WEST SUSSEX COUNTY COUNCIL CONSULTATION

TO:	Arun District Council FAO: Anita Gardner
FROM:	Stephen Gee WSCC - Highways Authority
DATE:	25 October 2019
LOCATION:	Former Poultry Farm Land West of Yapton Road Middleton on Sea PO22 6DY
SUBJECT:	M/80/19/PL Demolition of the existing structures & redevelopment to provide a new 66-bedroom care home (Use Class C2) arranged over two storeys together with associated access, car and cycle parking, structural landscaping and amenity space provision. Amended access arrangement plan received.
DATE OF SITE VISIT:	
RECOMMENDATION:	No Objection
S106 CONTRIBUTION TOTAL:

402.06594.00008:14.TR04.RevA.dwg

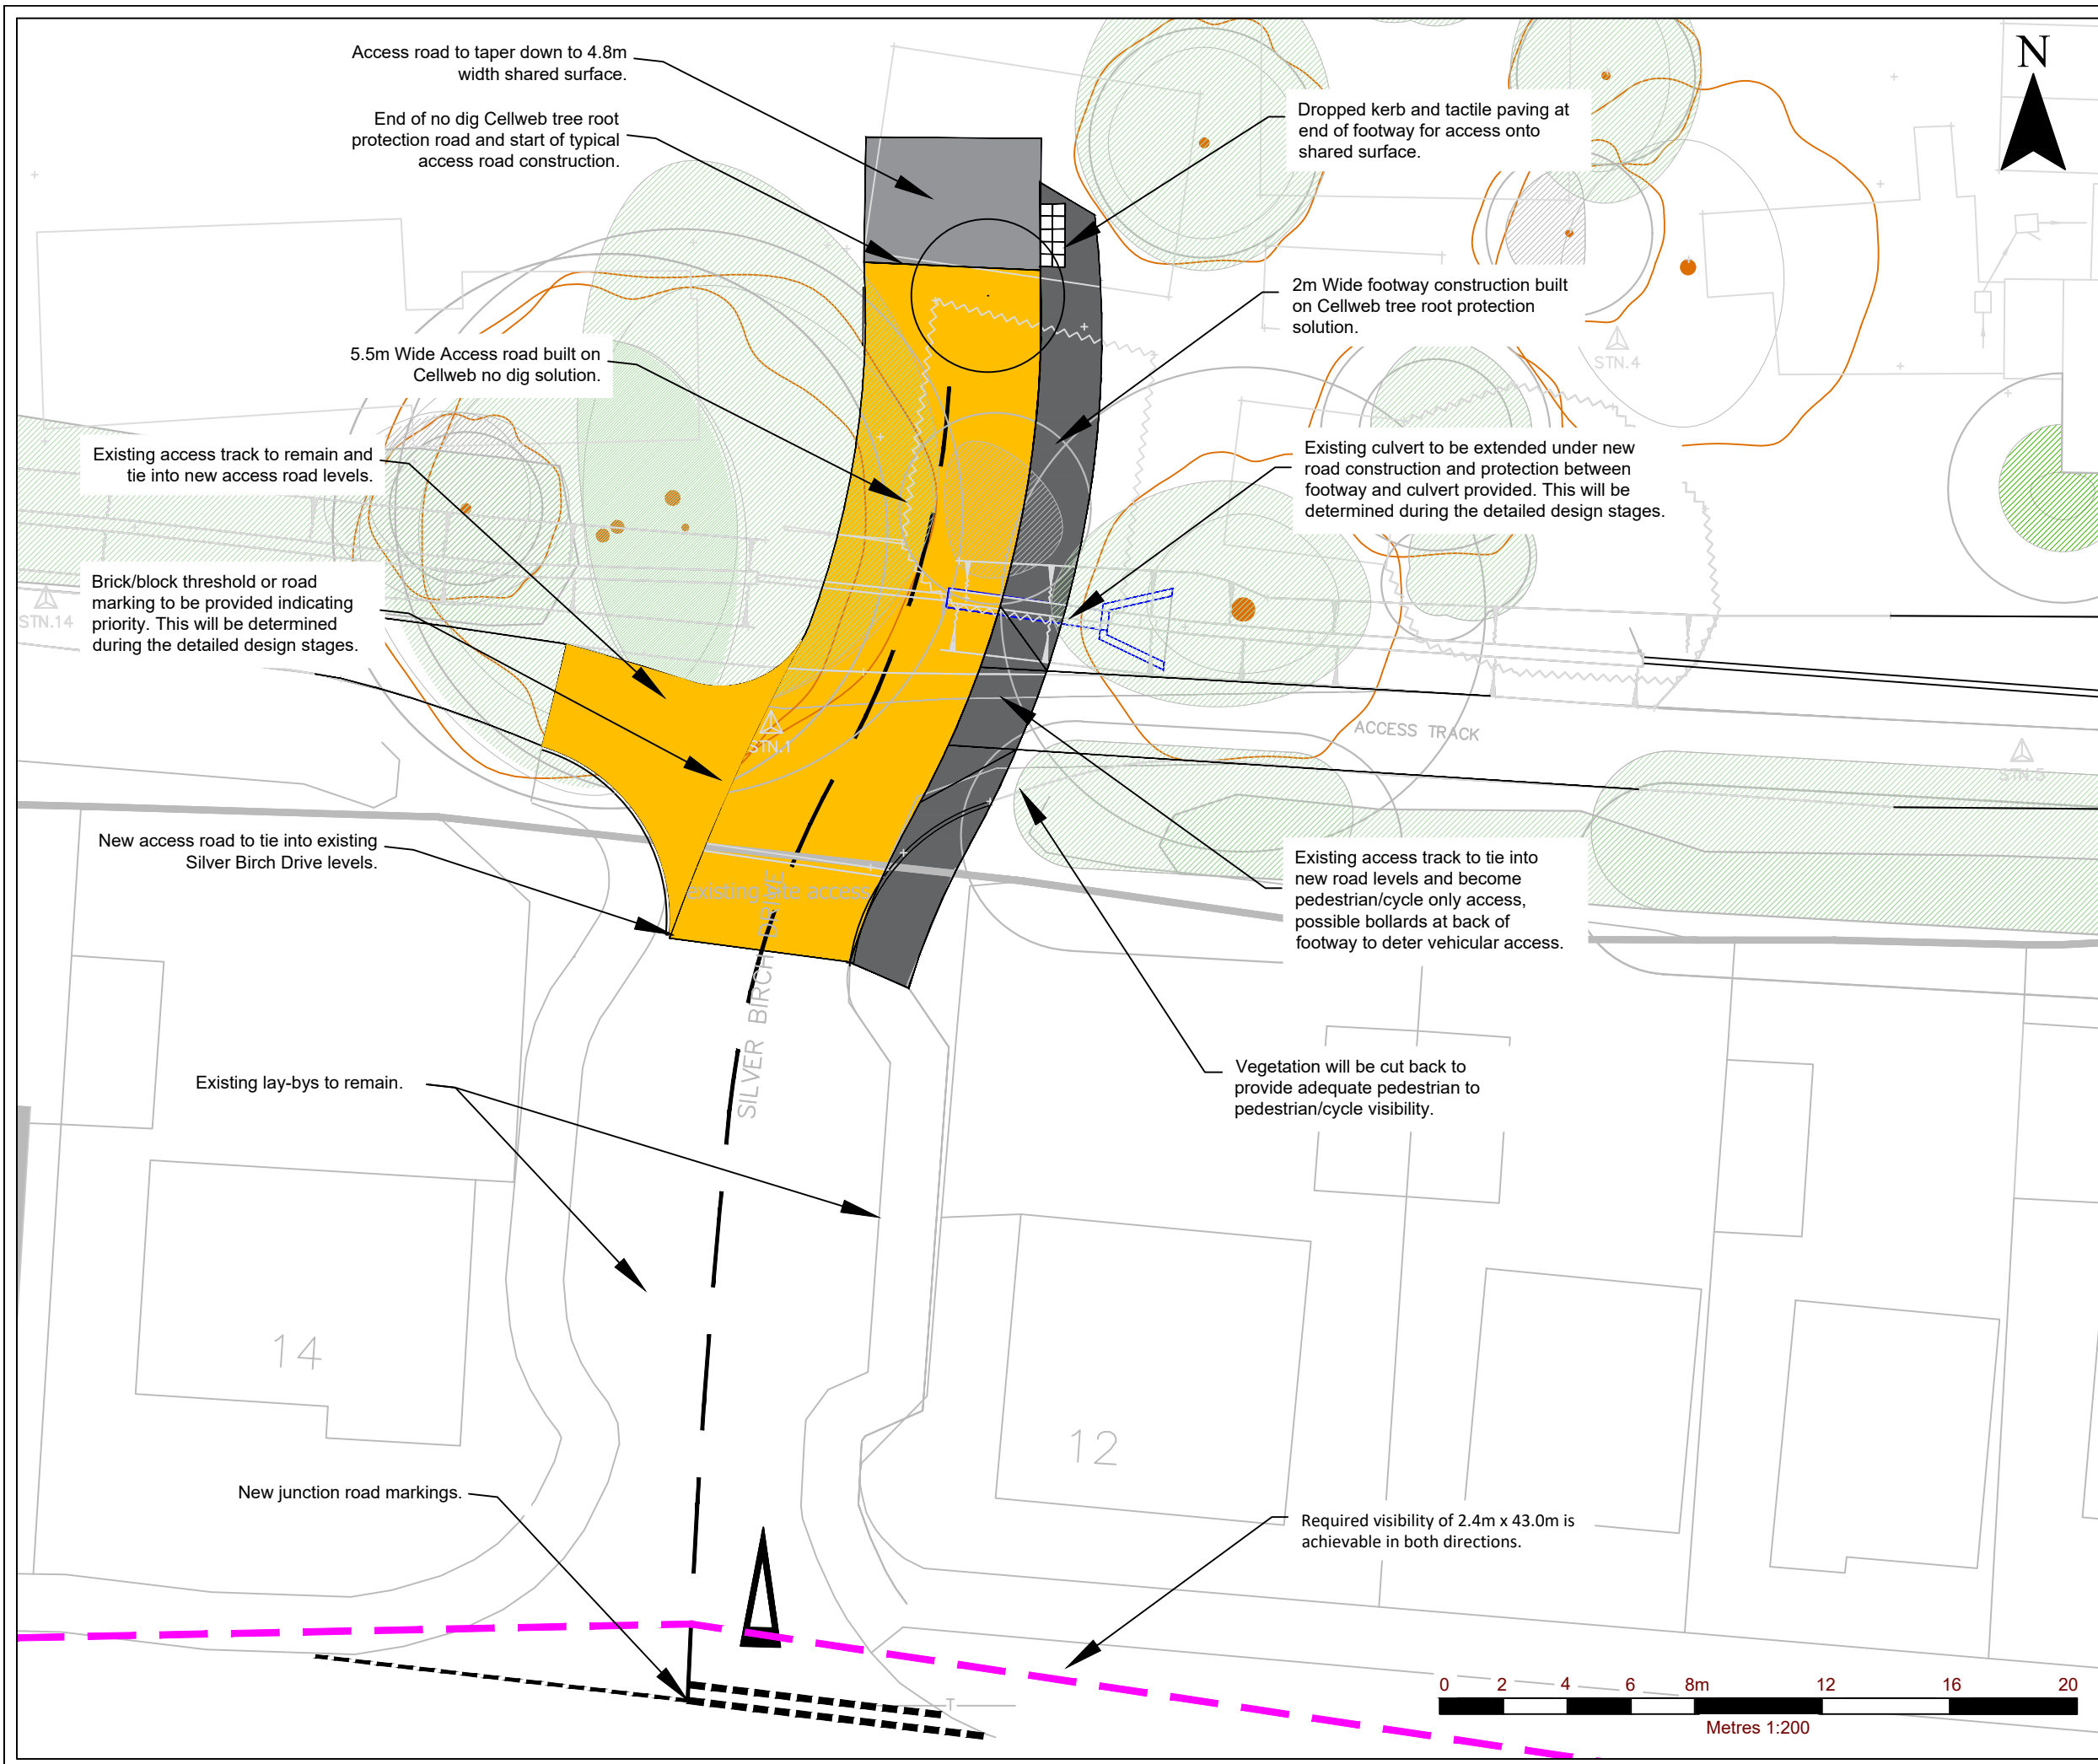
Following my first response the applicant has provided a stage 1 road safety audit and amended access design.

The audit highlighted 5 issues to which the designers accepts all 5 recommendations. The access should be secured by condition prior to the commencement of the development as suggested within the applicants draft construction management plan.

No part of the development shall be commenced until such time as the vehicular access serving the development has been constructed in accordance with the details shown on the drawing titled proposed access arrangements and numbered TR04 Rev A.
